OEH Detailed Comments on MPE Stage 2 RTS BAR

Figure 7-1 Threatened flora species recorded within and adjacent of the Amended Proposal

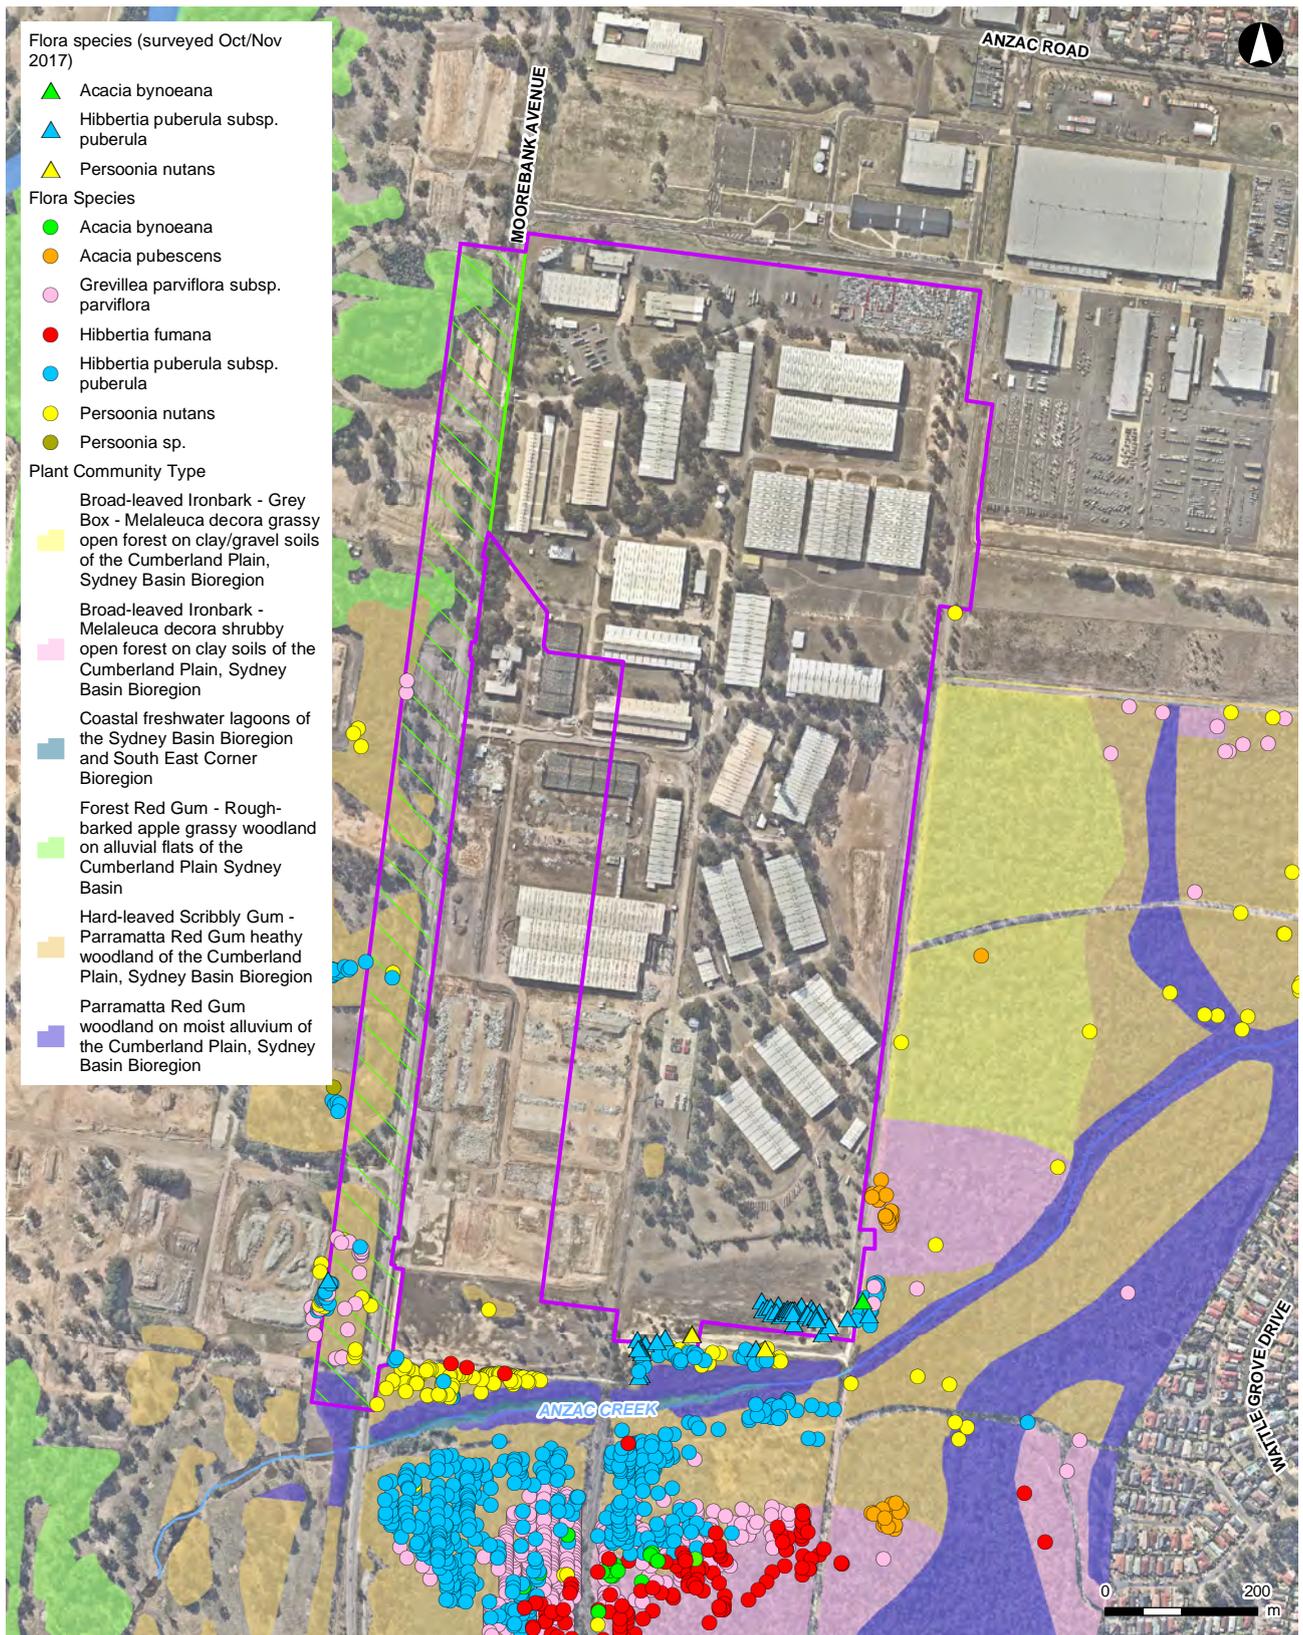
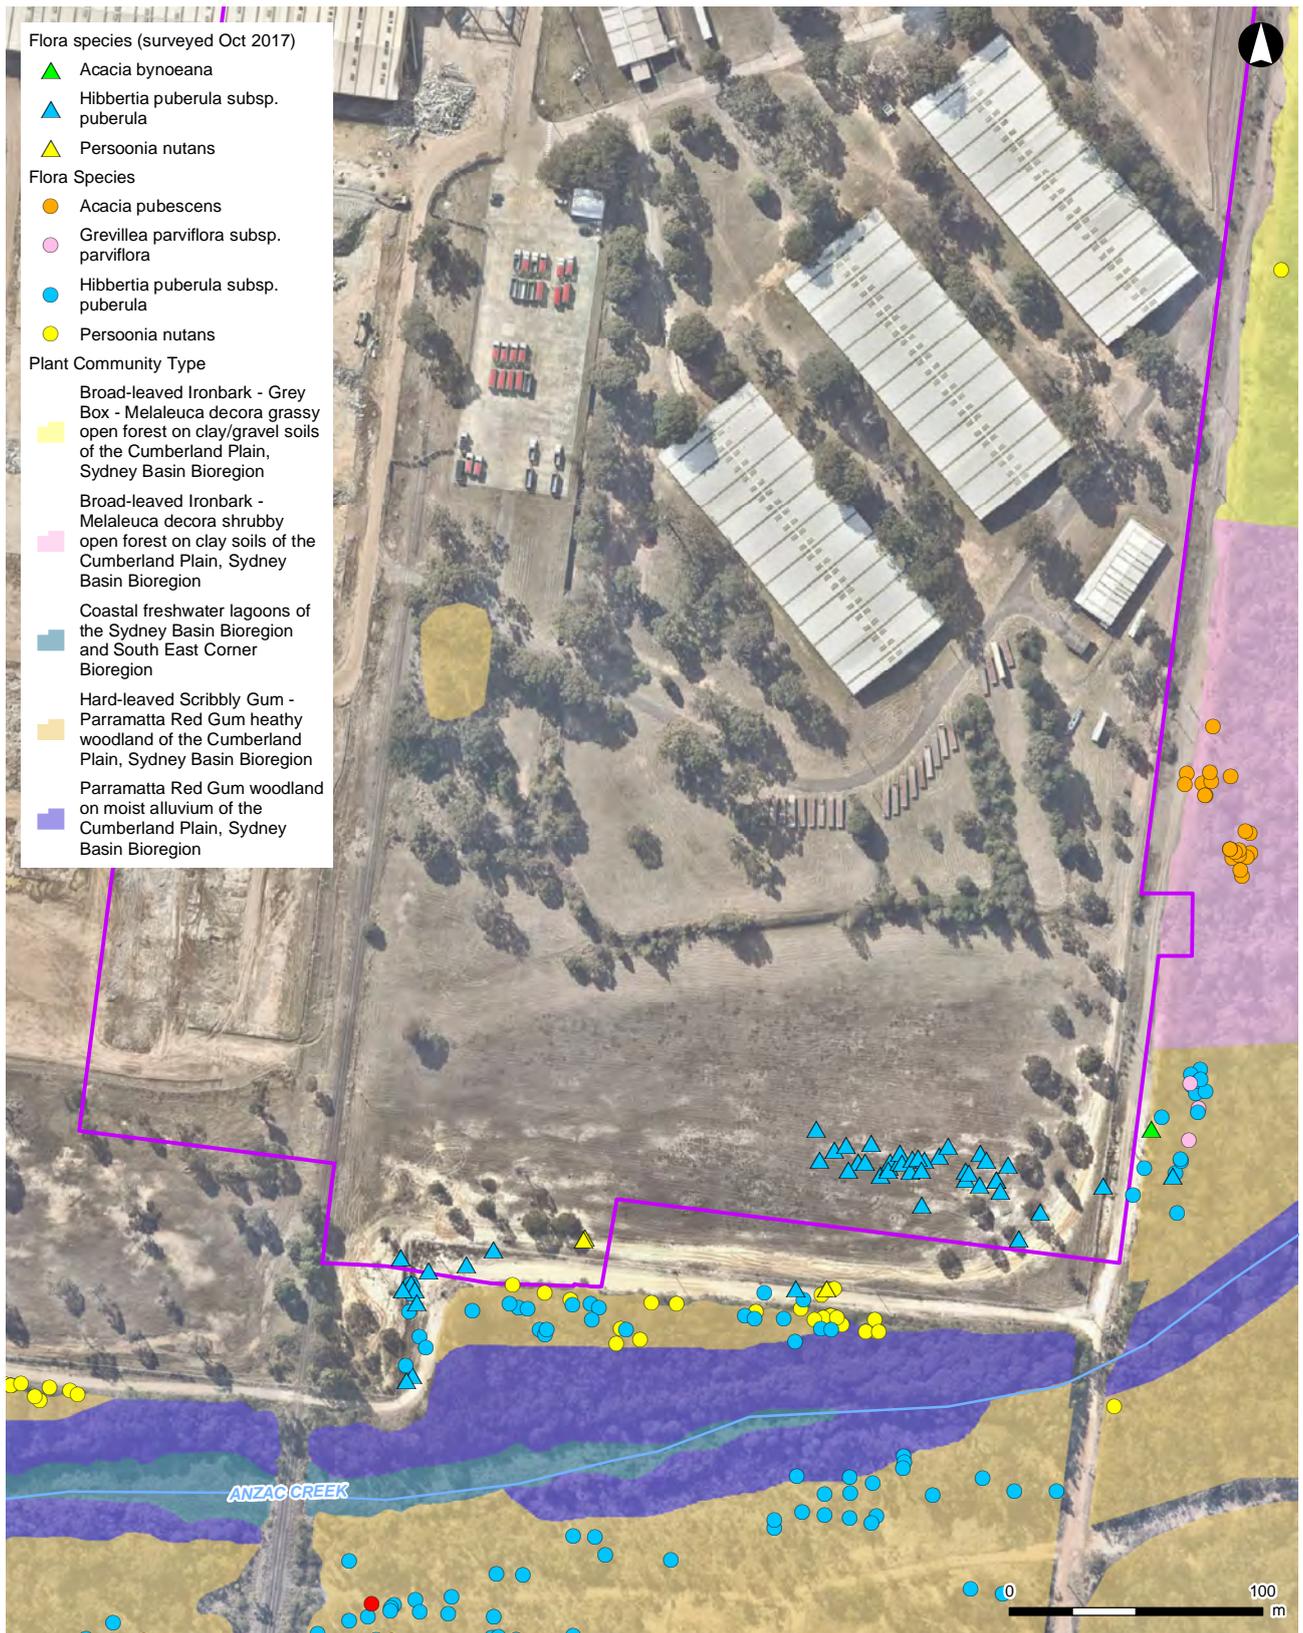
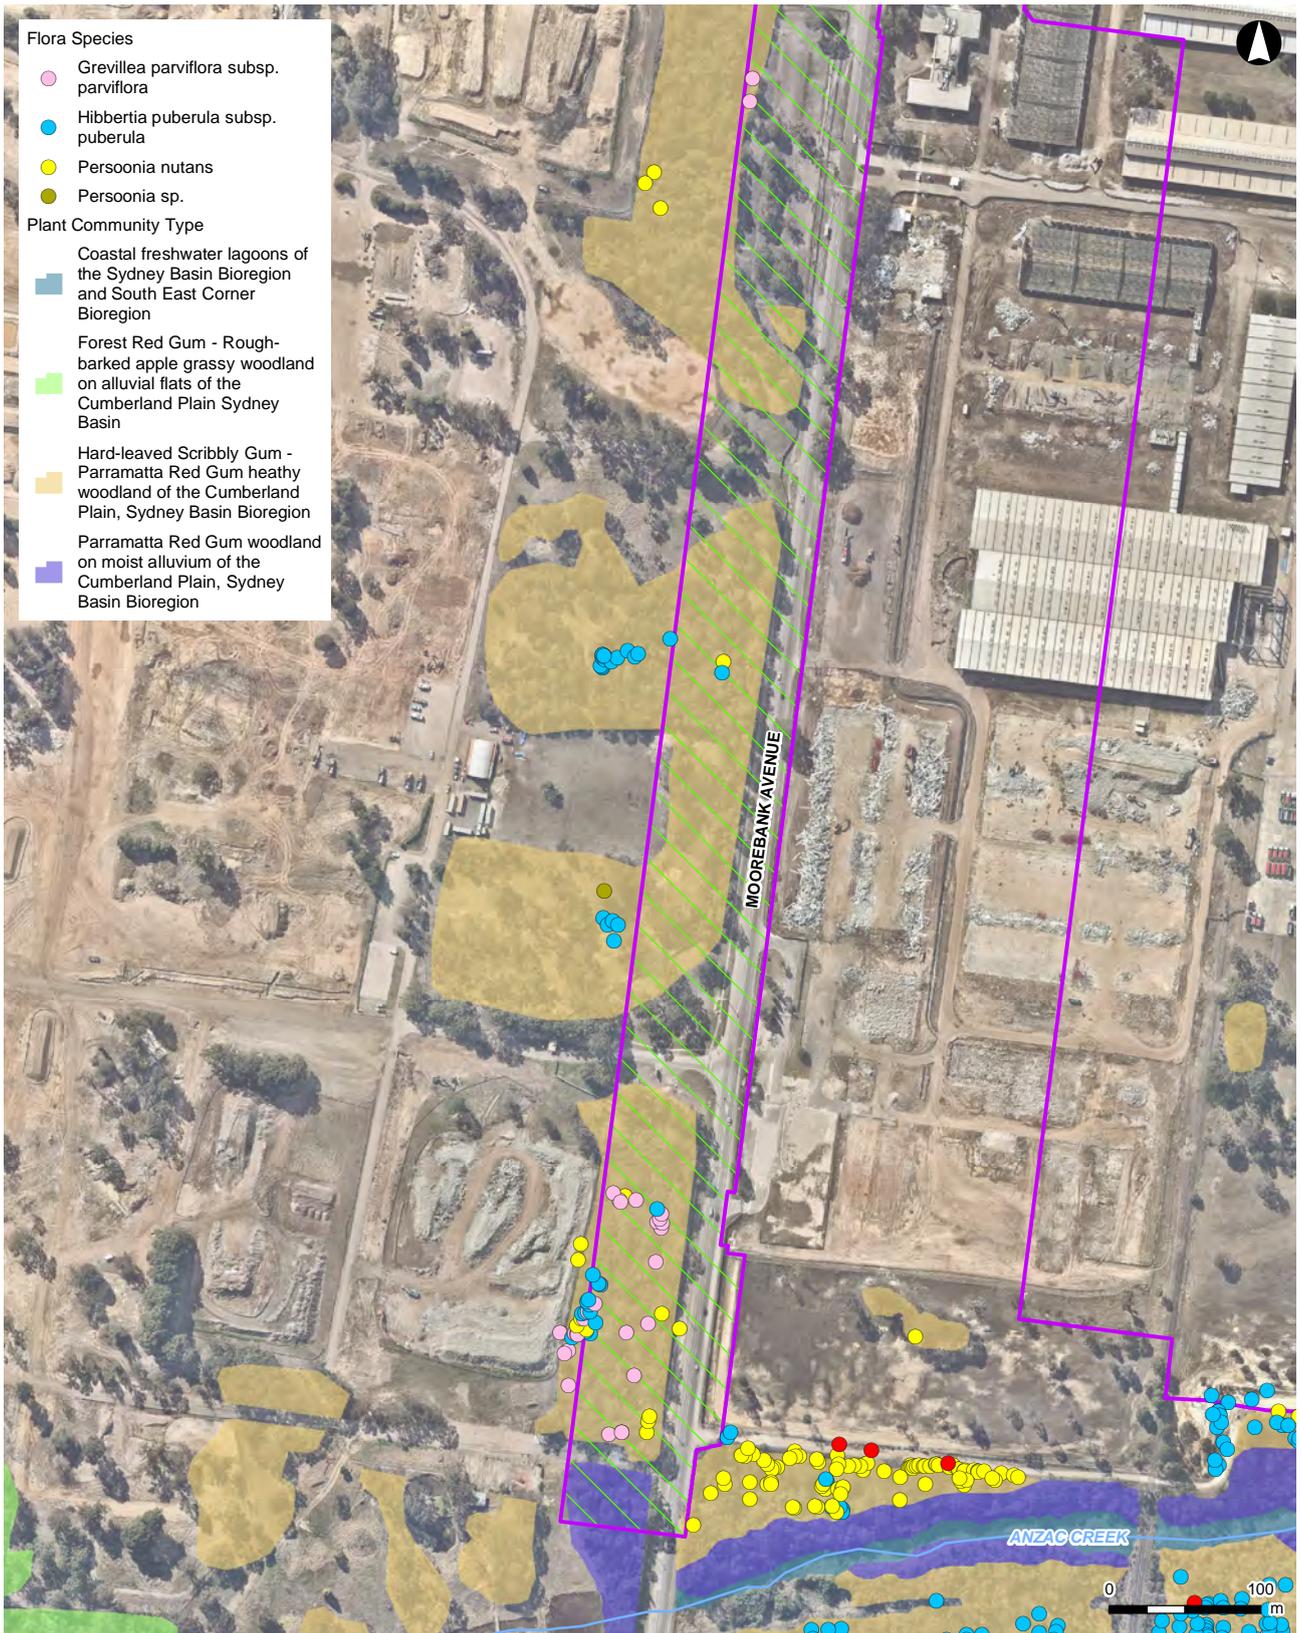
71/Grevillea	Further Action	The species is flagged as 'Not required' for further action, despite being within the Moorebank Avenue site (and therefore impacted).
80/fumana	Discussion	The plant was presumed to be extinct when formally published in 2012. There are still issues with clarification of the methods and data used to assert such a high number of individuals which will need to be cross-verified by OEH.
84/s7.2.2	Fauna	Another species is in the tool – Black Bittern. This is not included in the list of species here. In addition, there is no discussion of the landscape species identified.
88/Regent honeyeater	Presence	10 km is too small a search boundary for a critically endangered species which infrequently uses the coastal woodlands. It has been recorded from Campbelltown since 2011.
105/s10	Triage	The principle is to avoid or minimise, then offset (Act), not 'and'. One must be done first, leading to the others in priority.

Figure 10-1: Proposed biobank site

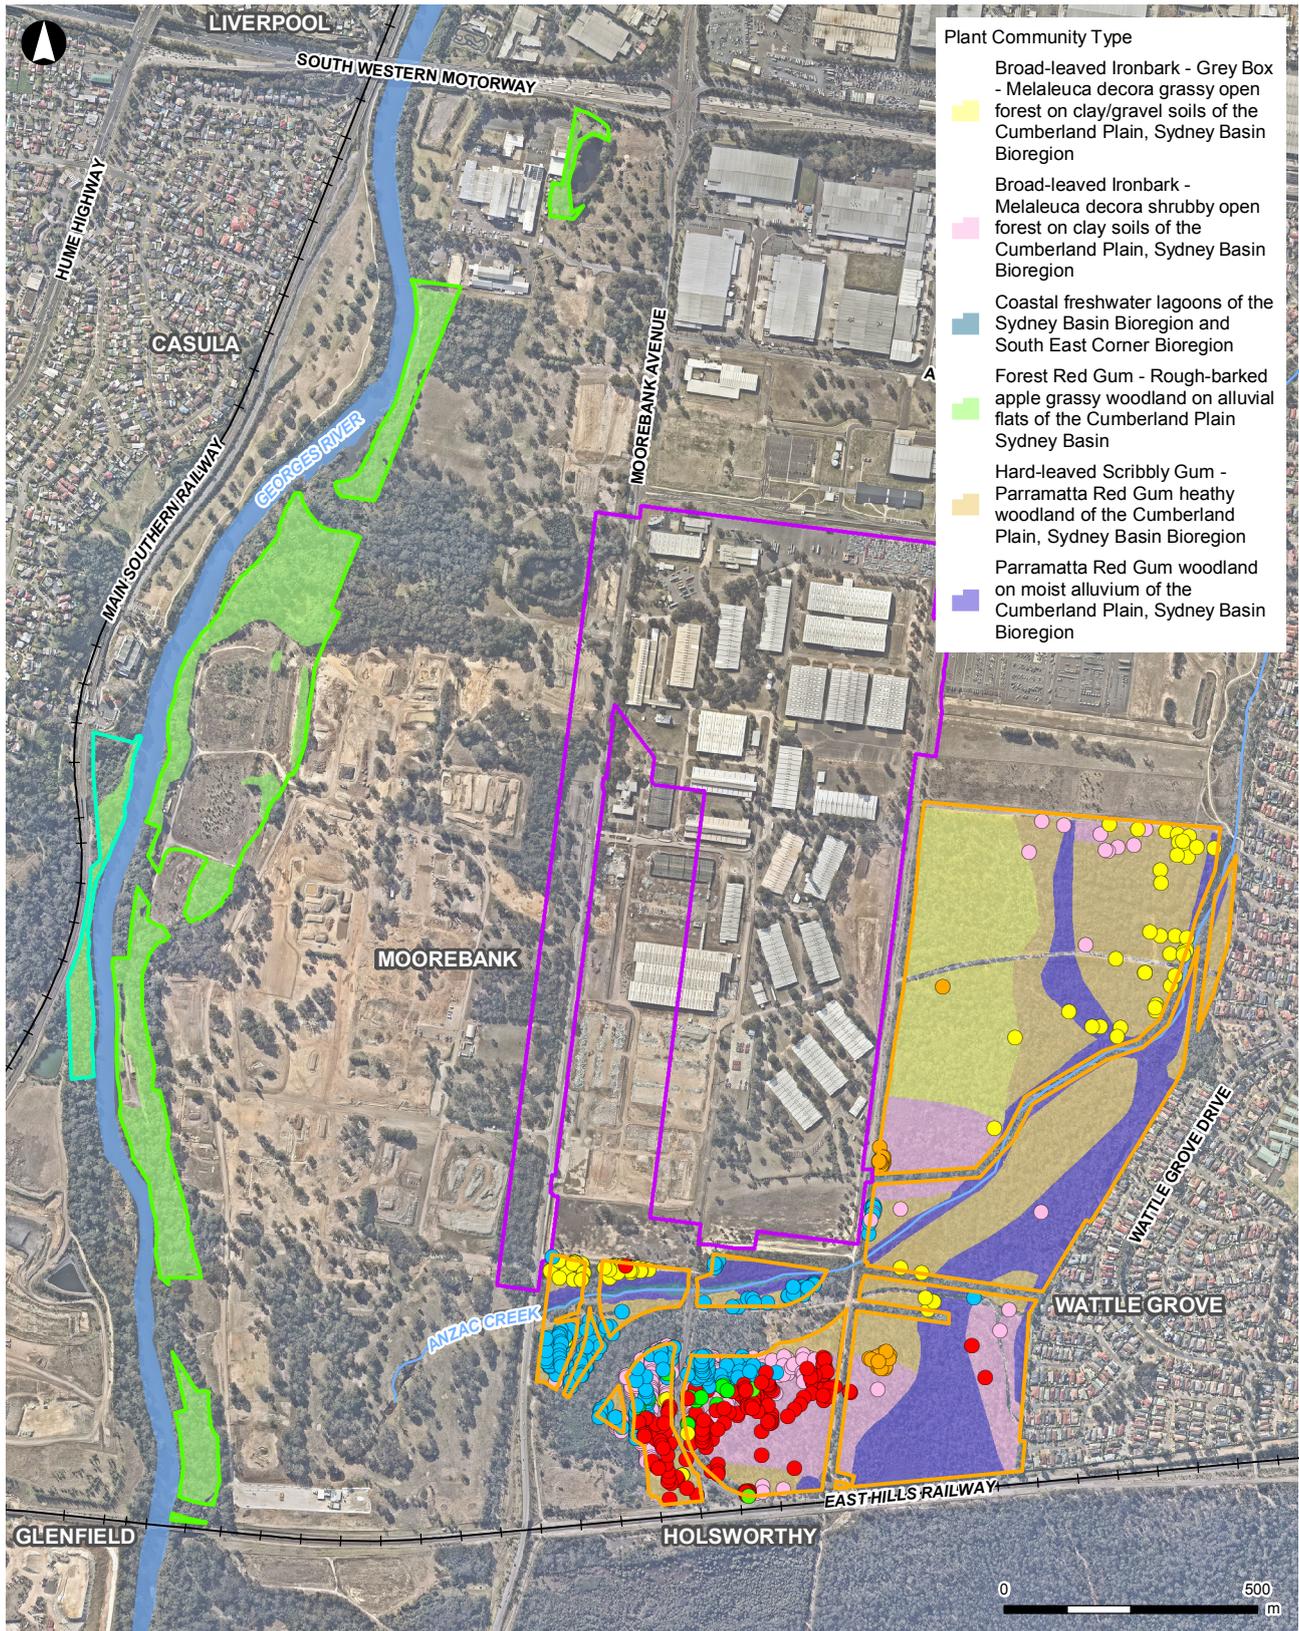
6/d	Offsetting	While offsets are identified and are shown to occur in the adjacent lands, no identification of the amount of credits already committed for the existing and varied Stage 1 and MPW is shown. This leads to the belief that sufficient credits exist when this cannot be actually confirmed without the updated Stage 1 requirements included (and those affected by the pending Land and Environment Court decision). While most communities and species are adequately identified, there are concerns about the sufficiency of quantum of <i>Hibbertia puberula</i> in particular, given more have been identified in the rail corridor for Stage 1 than had previously been identified (this may be knowledge subject to court privilege at this stage).
7/management of TS	Response	The response here is materially incorrect.
7/off-set	Response	There is no Section 12 in the report. It may mean Section 10, where the offsets
